Your Ref: OWPC5544
Our Ref: LU/106/15/PL 20-03-2015
Please ask for:
Ross Leal

Variation of condition 3 imposed under planning reference LU/203/13/ to enable the reorientation of plots 5 & 6.

Willowbank Cottages The Poplars Littlehampton

1-6 Willowbank Cottages
The Poplars (Former HRI Site)
Worthing Road , Littlehampton
West Sussex. BN17 6AZ
EAST AND WEST ELEVATIONS
PLOTS 1-4

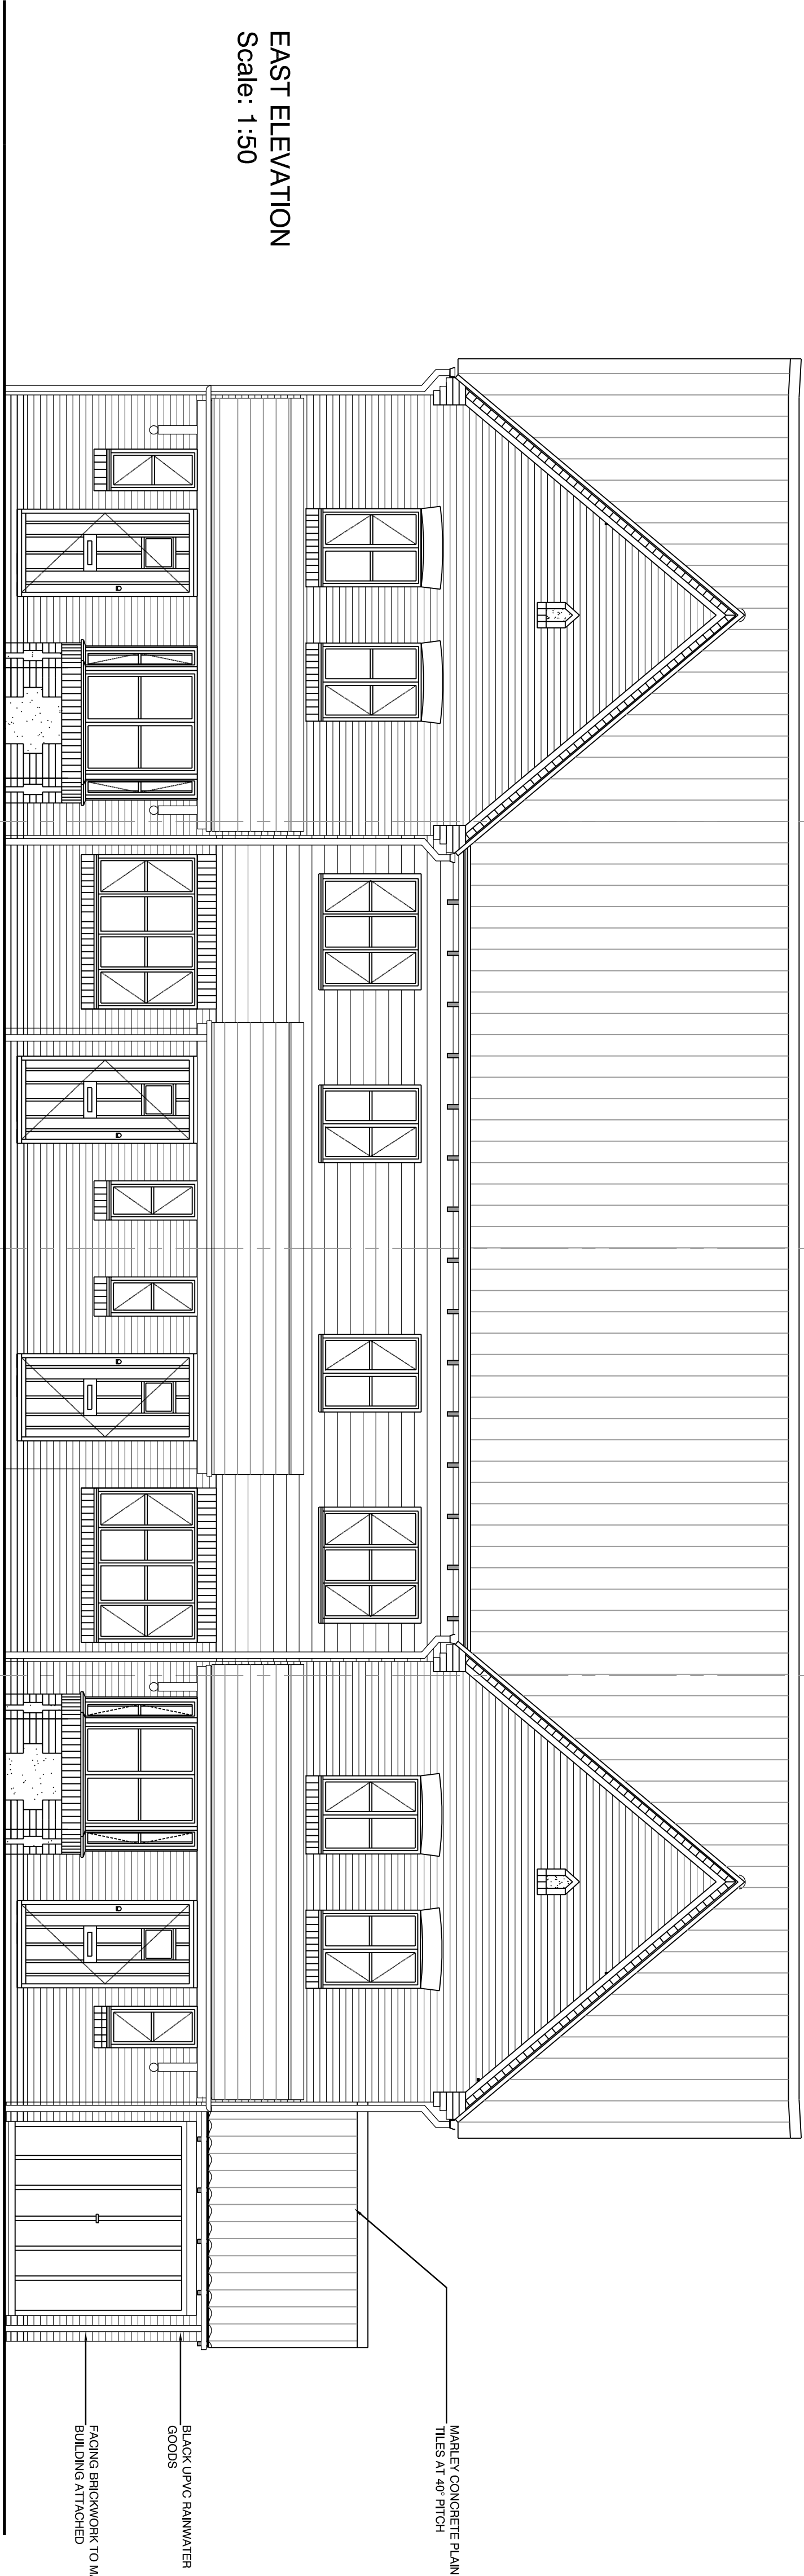
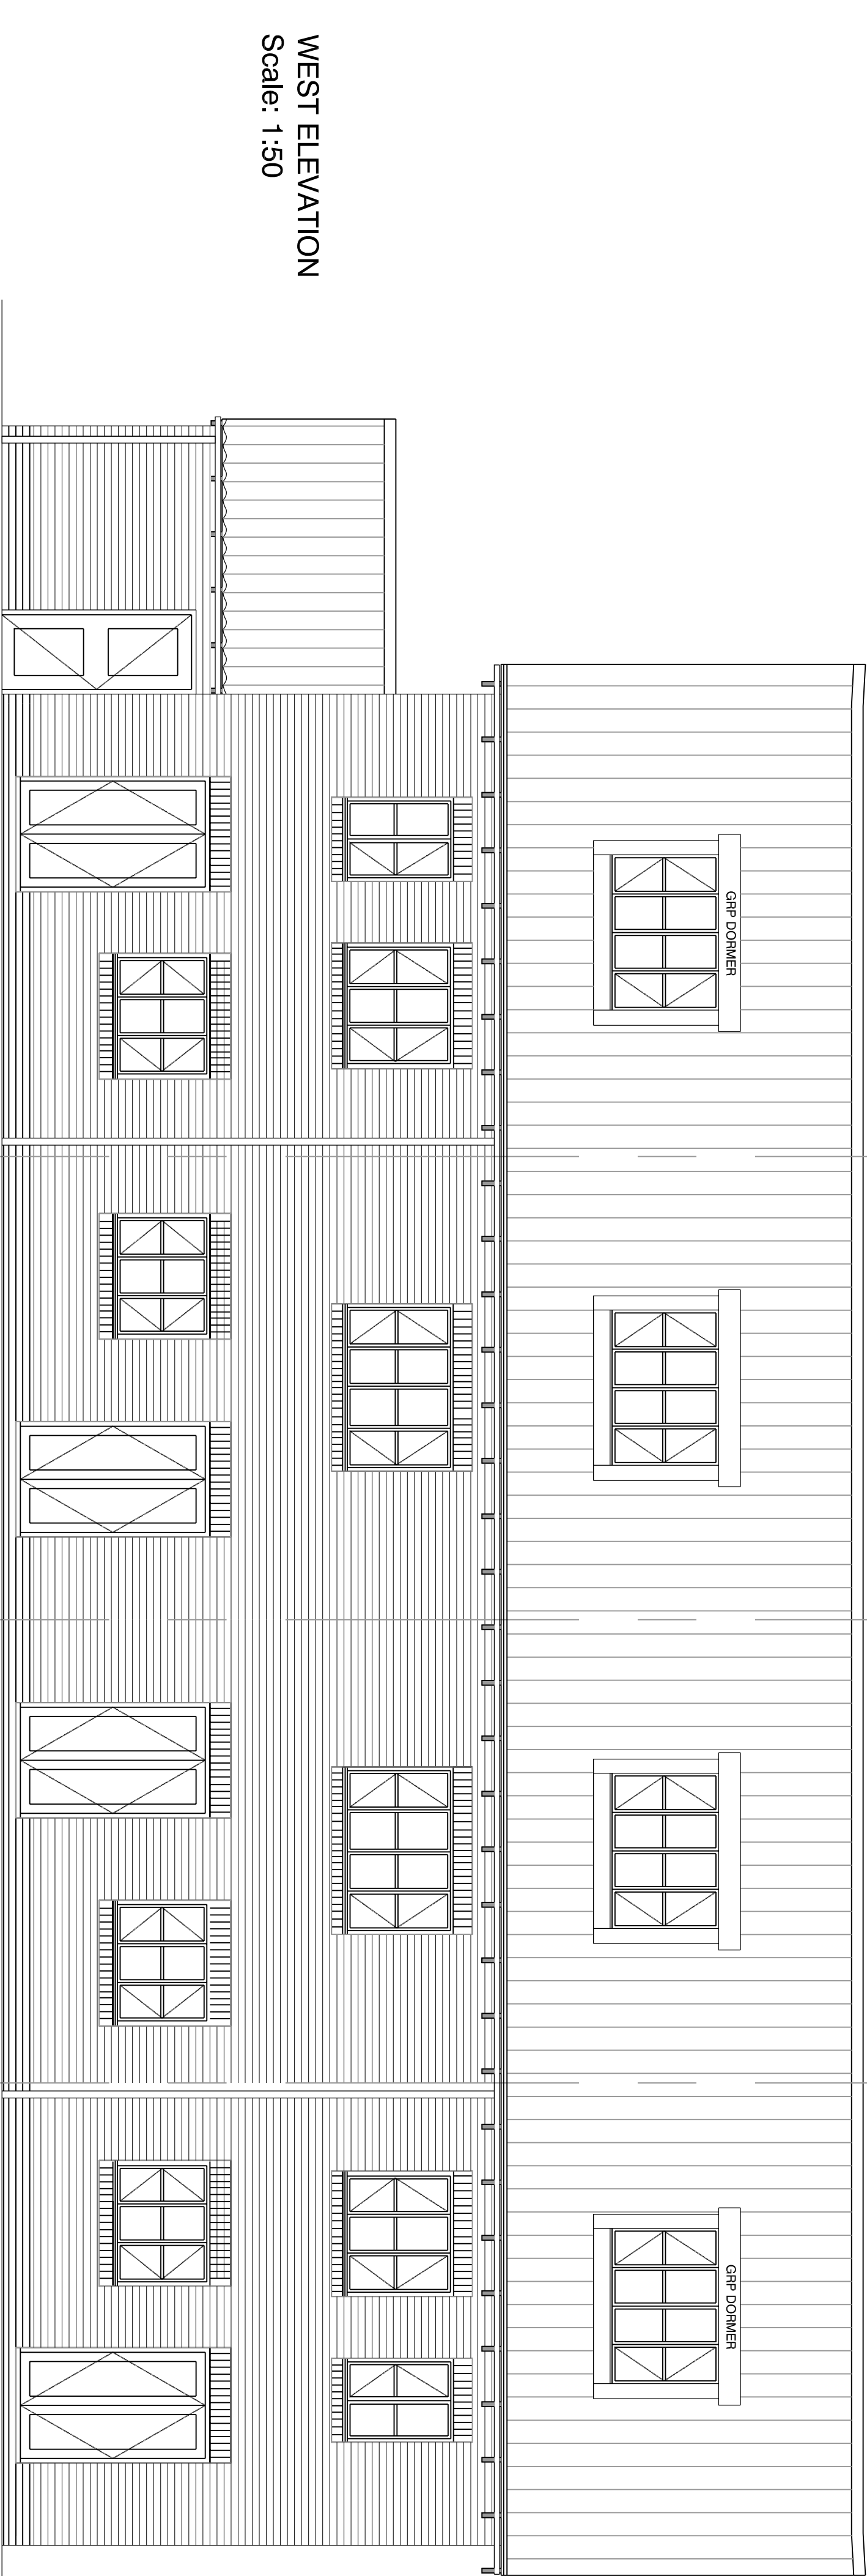
- 1. There will be 2 garages backing onto the rear of my garden. These will block light and reduce the amount of sun that reaches the garden.*
- 2. Parking on the development is already oversubscribed and this will result in even more problems. The area is unsafe due to these issues as there is poor visibility due to parked cars.*
- 3. There is a 12" water main that runs through the site and also a pumped sewerage main. Damage to these could result in serious flooding and damage to surrounding properties.*
